## MODIFICATION 2 – NEWCASTLE PRIVATE HOSPITAL REDEVELOPMENT

### SUMMARY RESPONSE TABLE TO SUBMISSIONS

GENERAL ARRANGEMENT GROUND FLOOR PLAN
1:200

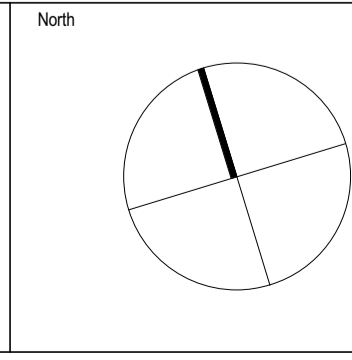
<b>PEDESTRIAN NETWORK</b>	To minimise the potential for vehicular / pedestrian conflict it is recommended the design of the modified project be amended to include a designated pedestrian pathway within the new at-grade car park between bays No. 5 to 14, and 24 to 31, linking to the 'Kingston' and 'Croudace'	The design approach to the at-grade car park area between the Kingston and Croudace buildings had been to re-align car parking arrangements to reduce parking and pedestrian impacts on the hospital road while addressing the changes in levels.

GOVERNMENT DEPARTMENT / AGENCY	ISSUE	SUMMARY OF ISSUES RAISED	RESPONSE
		buildings.	<p>The difficulty in providing the pedestrian footpath as requested by Council is that there is a significant change of level between the two rows of parking. It is noted however, that there is an existing footpath adjacent to the car park linking the Croudace Building and Kingston Building that can be used by pedestrians, and a footpath addition is now proposed adjoining the accessible parking bay (bay 31 and associated shared zone) in the at-grade car park to direct pedestrians from the lower level of the car park to the footpath linking to the Kingston Building and subsequently the Croudace Building. Drawing SK210 (at <b>Appendix B</b> of the Response to Submissions report) has been amended to identify the access pathway addition.</p>
	<b>SERVICING</b>	<p>Another concern raised in Council's previous submission which has not been addressed is confirmation that the loading service area proposed off Jacaranda Drive is designed to cater for all service vehicles with forward entry and exit and adequate driver sight distance has been provided for drivers exiting the service area onto Jacaranda Drive.</p>	<p>The servicing comments were addressed in detail in the ADW Johnson response to submissions dated 7<sup>th</sup> October, 2009, and incorporated into the project design (refer to these previous comments below).</p> <p><i>"The architectural drawings attached at Appendix C include the turning template of a 9m rigid truck on plan No. SK103. This clearly shows a truck of this size can enter and leave the dock in a forward manoeuvre.</i></p> <p><i>The building is set back from the (near) road kerb alignment by some 8 metres at the lower levels to facilitate visibility. Only the dock awning projects closer to the public footpath, and has a semi transparent dividing screen at its eastern end. The screen has been designed out of steel with proprietary aluminium louvers to filter visibility of dock activities from outside, whilst allowing traffic to detect vehicle movements from both inside and outside.</i></p> <p><i>The design of this area has considered the safe movement of all traffic in this area. The hospital portion of the building does step closer to the road alignment, however this is over two storeys (6.8 metres) above dock and road alignment level, where traffic and road visibility is not impacted.</i></p> <p><i>The visibility will be supplemented by a mirror on the</i></p>

202 BASEMENT LEVEL B2 PLAN - EXTENSION
1:200

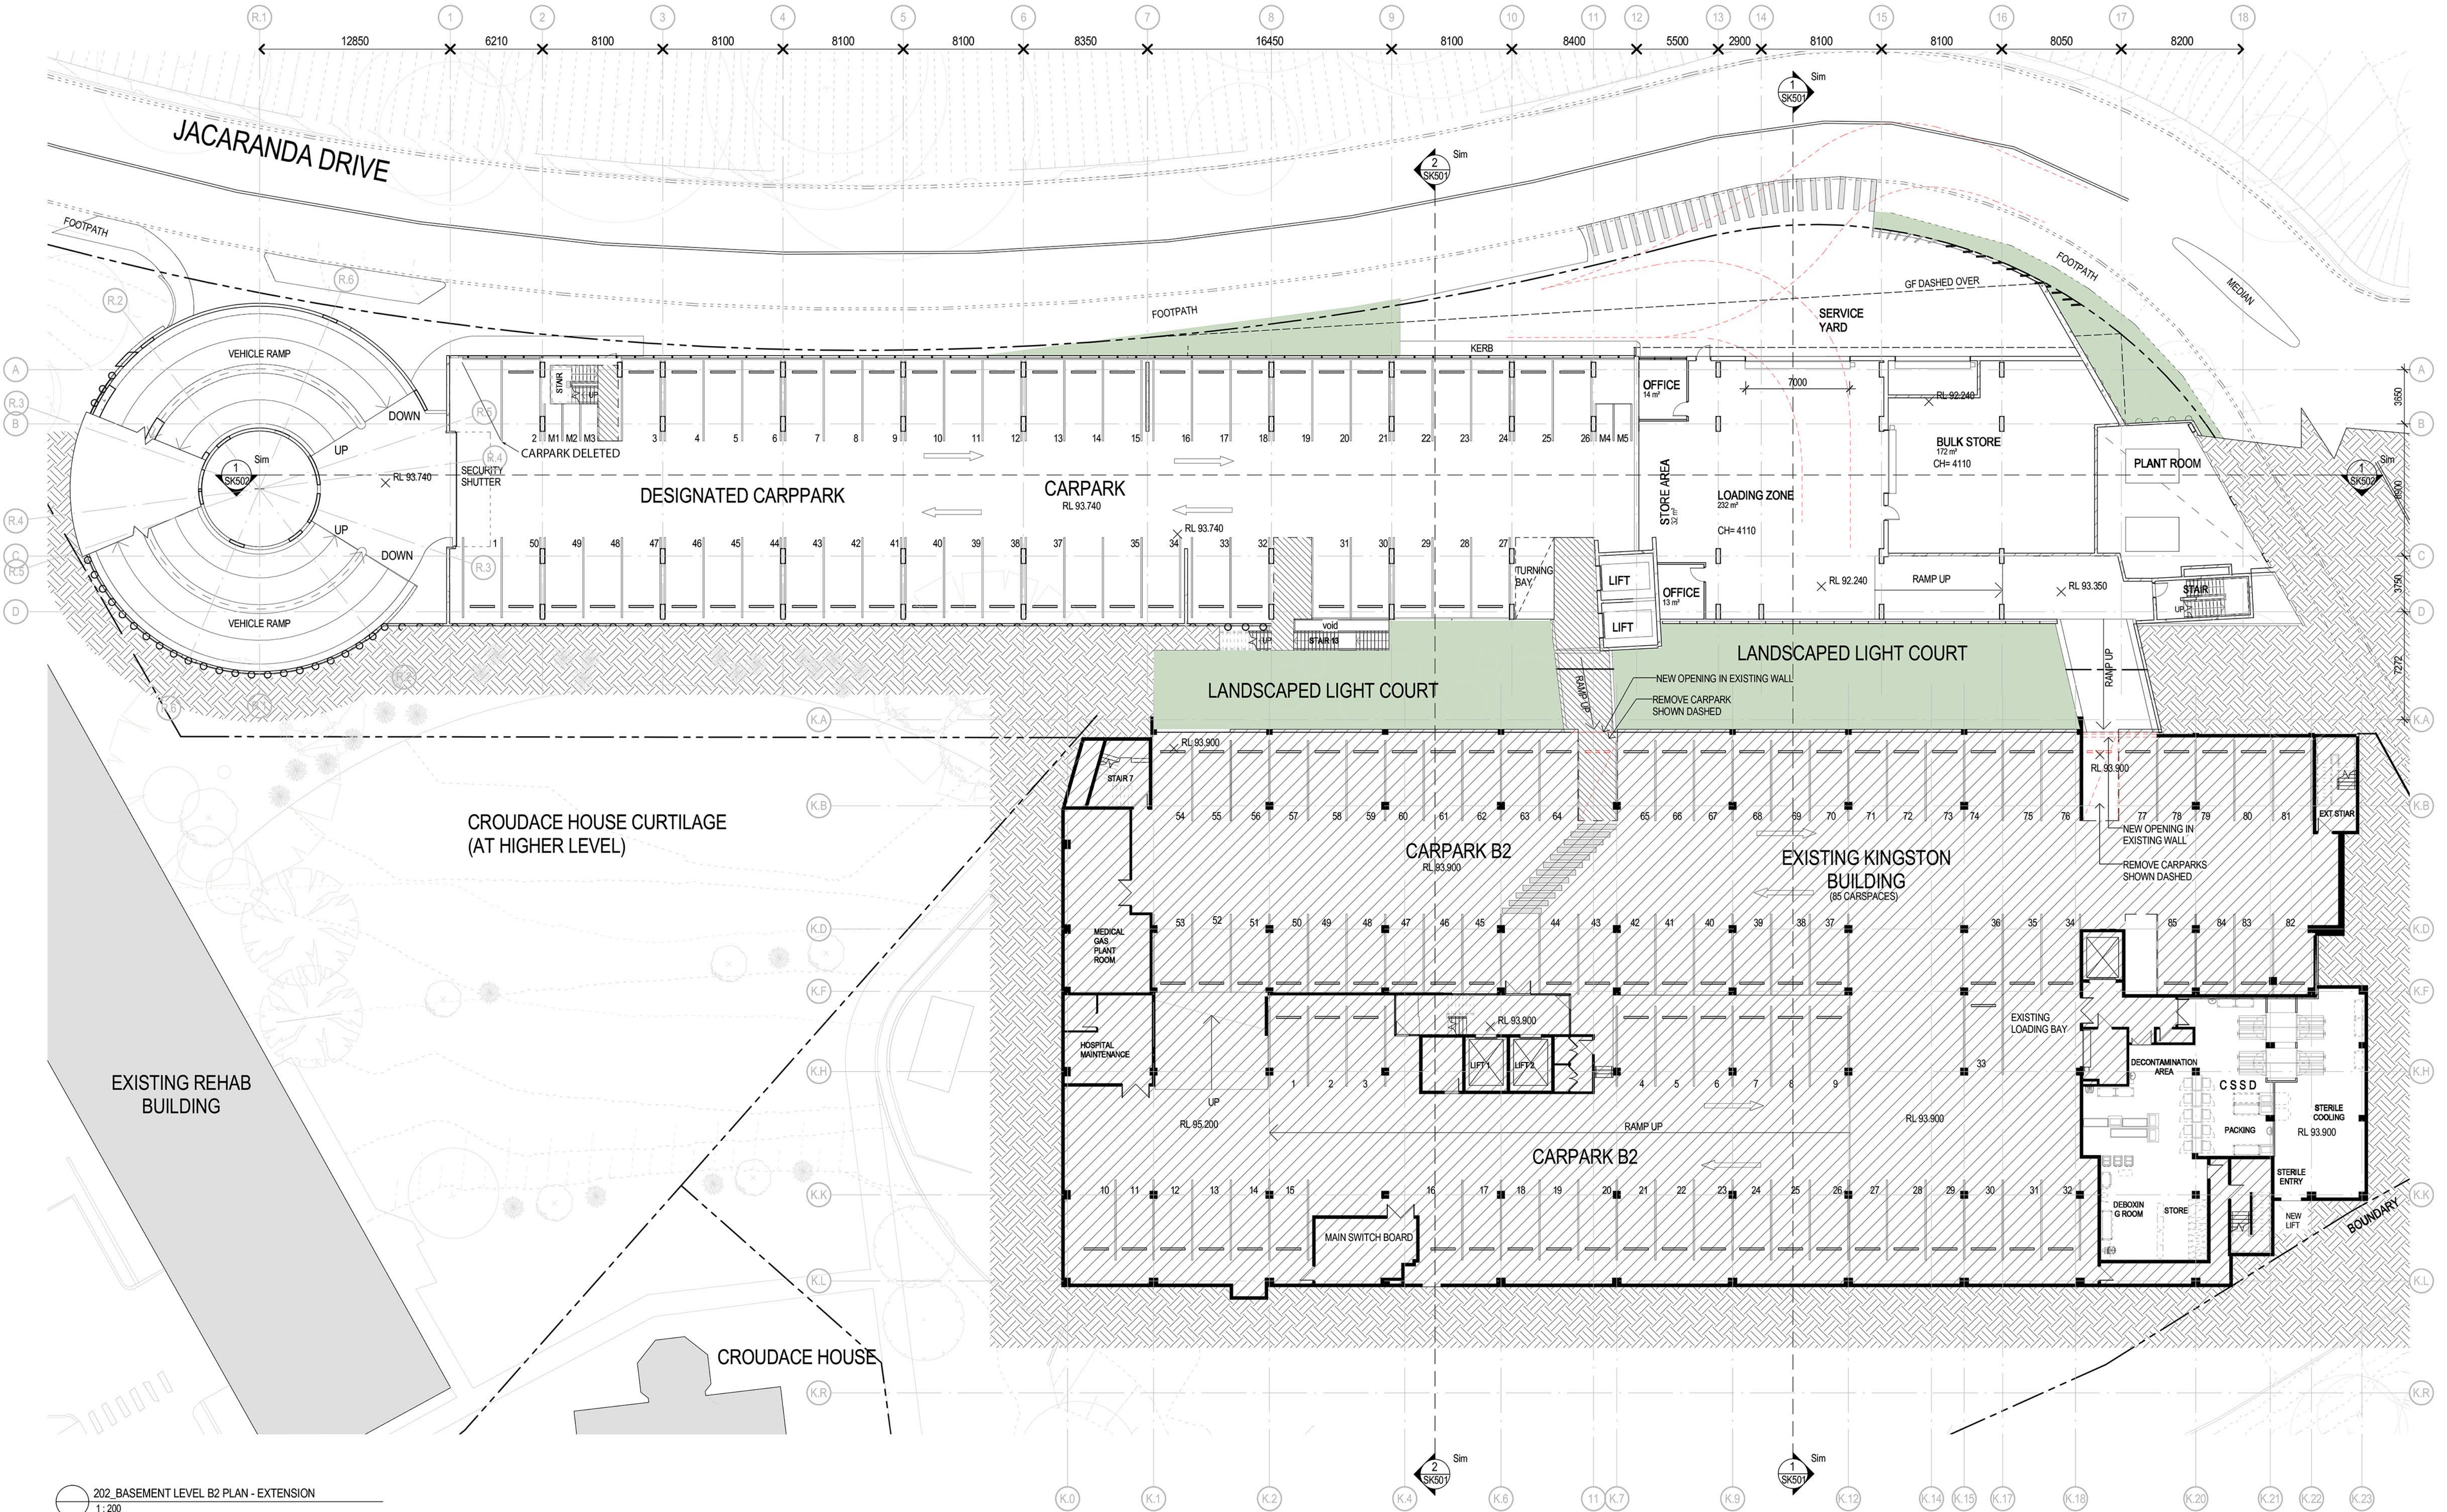
<b>CAR PARK LAYOUT</b>	Council's previous submission of 24 July, 2009 raised safety concerns in the relation to the proximity of proposed parking spaces to the access ramps at each level in the parking station. Driver sight lines are considered to be compromised thereby increasing the potential for vehicle conflict. This issue has not been addressed by the traffic consultant's report and needs to be reviewed and resolved prior to the determination of the modification request.	<p>The modified development (as updated) has now removed three (3) car parking spaces near the access ramps (one (1) on each basement level [B3, B2 and B1]).</p> <p>It is noted that the modification application initially submitted to DPE resulted in one (1) additional parking space (increasing the total from 382 to 383), and as such, the deletion of the three (3) parking spaces, will only result in a reduction of two (2) spaces, for a total parking provision of 380 spaces associated with the development.</p> <p>The deletion of the basement car park spaces near the access ramps will provide for improved driver sight lines into and out of the car park, and will have no material impact on parking supply.</p>
